24 December 2015

Our ref: DHB/15-322

**re: Submission to Exhibition of the Mod 4 of the CBD & South-East Light Rail Project  
– SSI 6042 (MOD 4)**

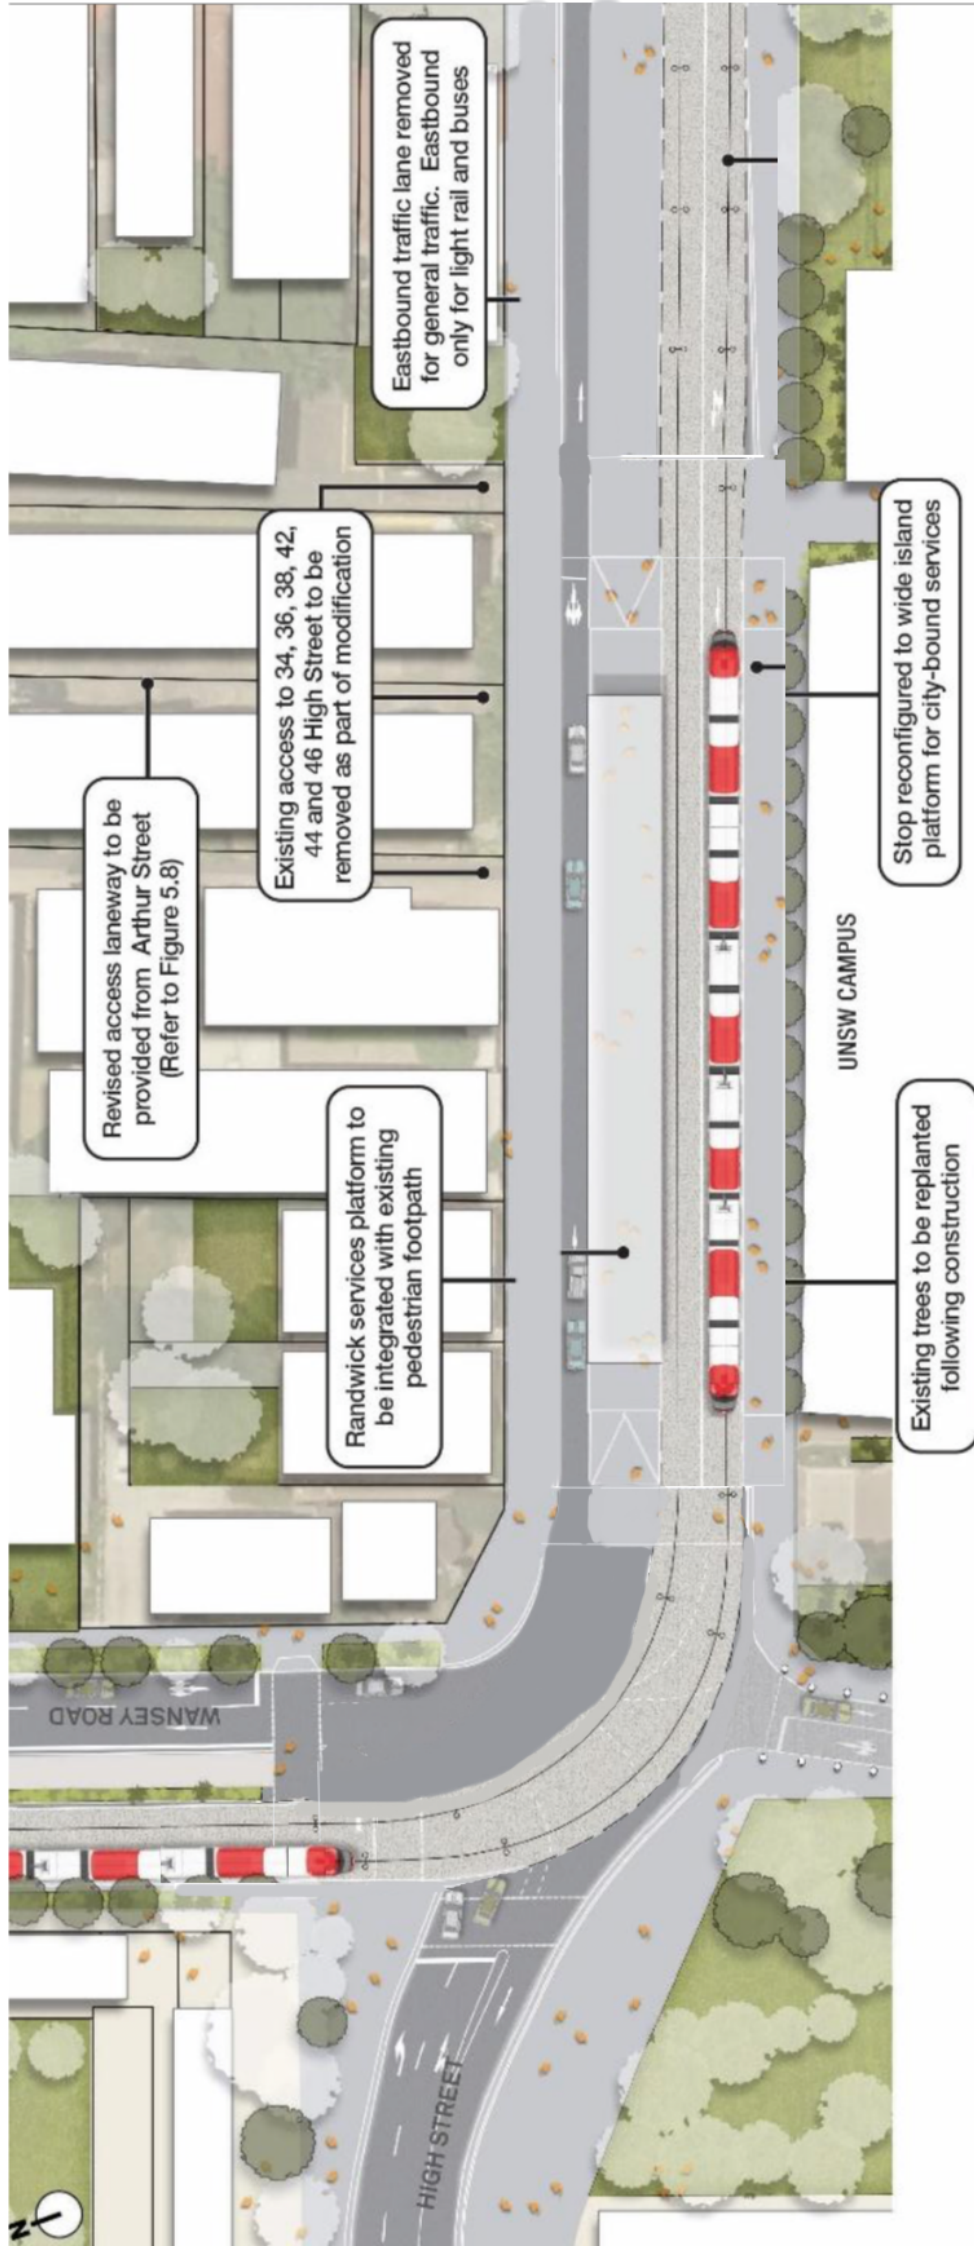
Mod 4 removes the only vehicular access to the site. This has significant implications on the operations on the colleges on the site and is objected to for the following reasons.

As stated in the Mod 4 application (Section 3.6 of the GTA Traffic Report), in order to maintain vehicle access to the site, *it is proposed that a new **public laneway** be provided from the rear of these properties to Arthur Street to provide a reconfigured driveway access to all four affected properties. The cul-de-sac would also be suitable to meet access requirements for vehicles such as garbage collection and removalist vehicles without the need to reverse along the new laneway.* (page 33)

This is not considered adequate and there is no understanding of what changes are required and how workable these would be. The costs of any internal re-configuration of garbage rooms and collection points need to be addressed. The location of such storage areas and implications for activities already on site such as car parking need to be resolved.

The new laneway access is proposed via Lot 1 in DP546495 with the existing driveway on this lot widened. It is clear that a significant proportion of traffic on this laneway would be delivery vehicles, service vehicles, garbage vehicles and the like in addition to private parking spaces. Providing a 6 metre wide laneway (presumably with splays at the intersection of Arthur Street and the laneway) is considered inadequate for the following reasons.

- rear lane access of this width would be purely utilitarian with no consideration to it being a pleasant and safe element of the street network, with sufficient 'address' to create activity and provide passive surveillance;
- no provision has been made for pedestrian access which is considered necessary given the use by larger vehicles;
- no allowance is made for drop-off of students or visitors;
- no provision is made for and form of landscaping along the length of the laneway;
- no consideration has been given to the principles of crime prevention through environmental design with a 6 meter laneway being potentially unsafe.

A significant increase in the width of the laneway would be required so that it can function as a properly designed element of the urban form with appropriate amenity and an appropriate address. The new public street should be designed in accordance with current streetscape urban design standards. Provision should be made for pedestrian access along the laneway

In addition to the loss of vehicular access, there would be the effective loss of footpath access as Mod 4 proposes that the footpath would become part of the light rail platform thus making it difficult for students, staff and visitor to access the site given that this access would be via a light rail platform. No details are provided of how this integration would be achieved and how welcoming it would be as a public footpath.

Consideration should be given to the performance of the intersection of Wansey Road and Arthur Street. The removal of the east bound lane on High Street would significantly increase traffic through this intersection. Improvements to this intersection may be required.
